The Lodge  
1 Armstrong Road  
Littlemore  
Oxford  
OX4 4XT

30<sup>th</sup> January 2018

**App 17/02534/OUT | OUTLINE - The construction of a business park of up to 60,000 sq.m (GEA) of flexible Class B1(a) office / Class B1(b) research & development floorspace; parking for up to 2,000 cars; and associated highways, infrastructure and earthworks | Land North Of Bicester Avenue Garden Centre Oxford Road Bicester**

Drawing Title
Parameters Plan

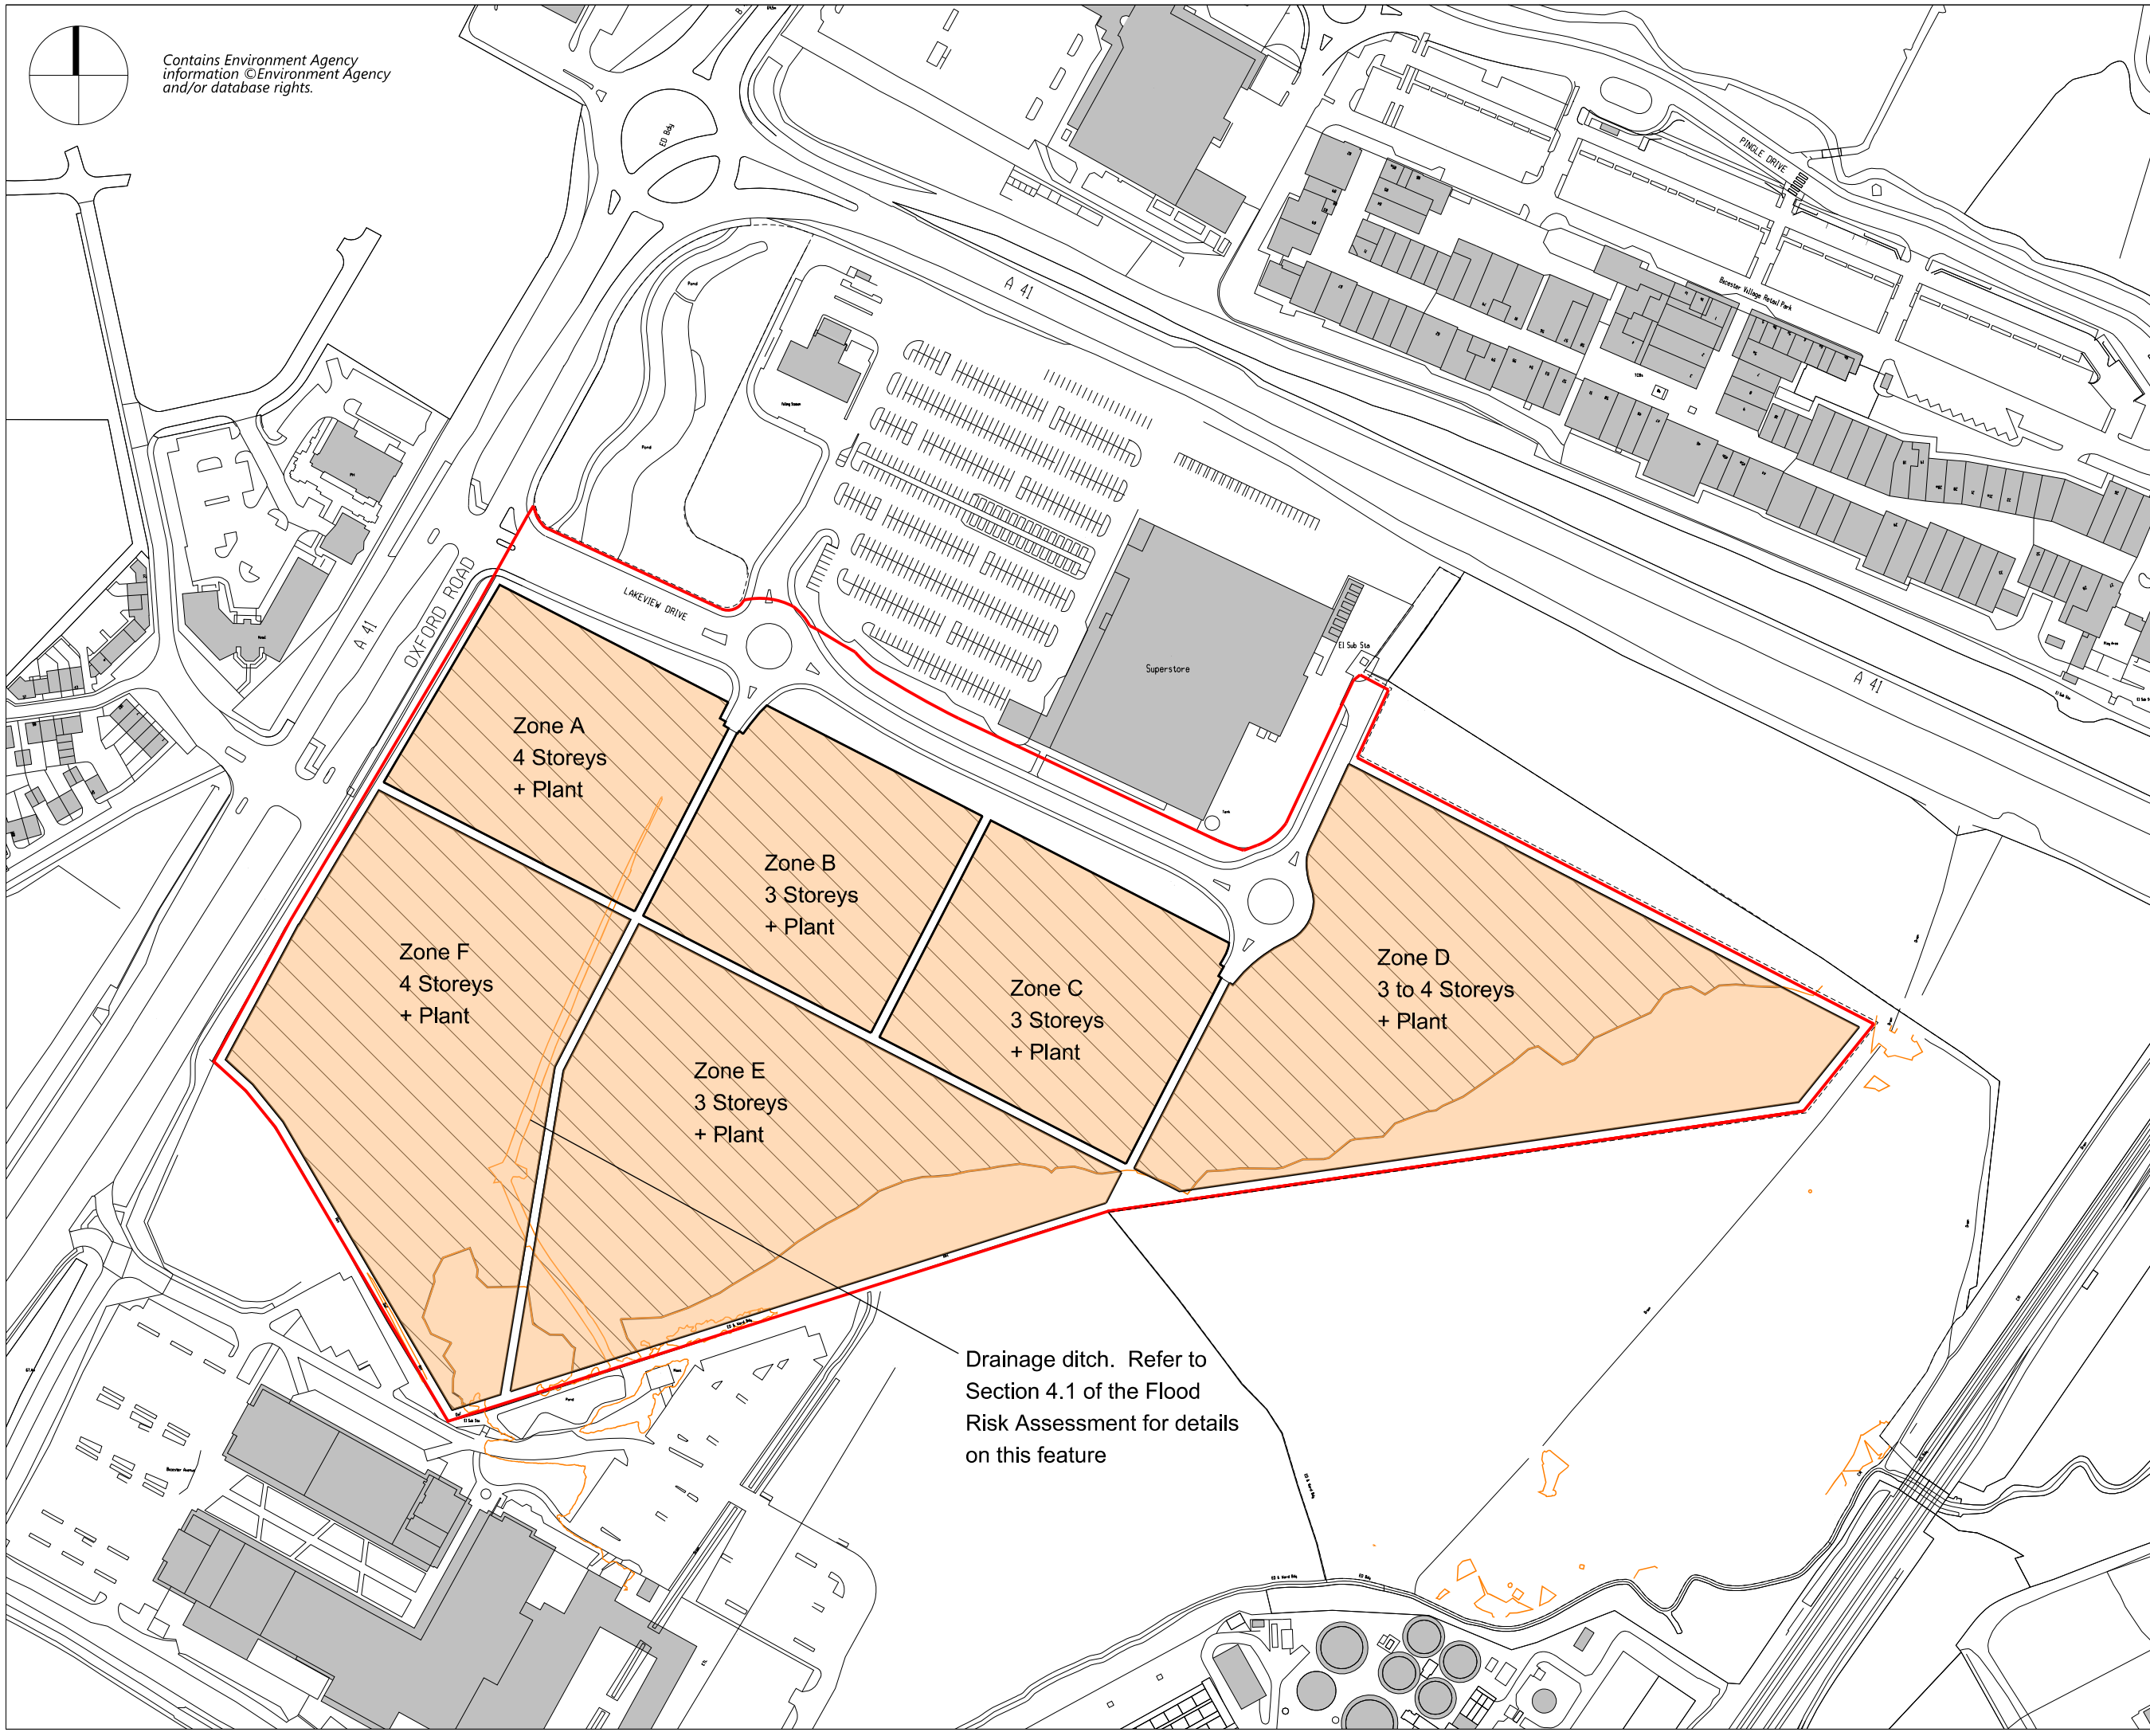
National (NPPF) and local policies (ESD10) require major developments to achieve a net gain in biodiversity. The Indicative Masterplan shows the majority of the application site being taken over by buildings and hardstanding, interspersed with smaller areas of largely formal landscaping. A narrow strip of wildflower meadow is proposed at the eastern edge.

We are unconvinced that the proposed development will deliver a net gain in biodiversity as required. The Biodiversity Impact Assessment Calculator (BIAC) is an accepted and useful tool in quantifying losses and gains in biodiversity and should be requested prior to determination.
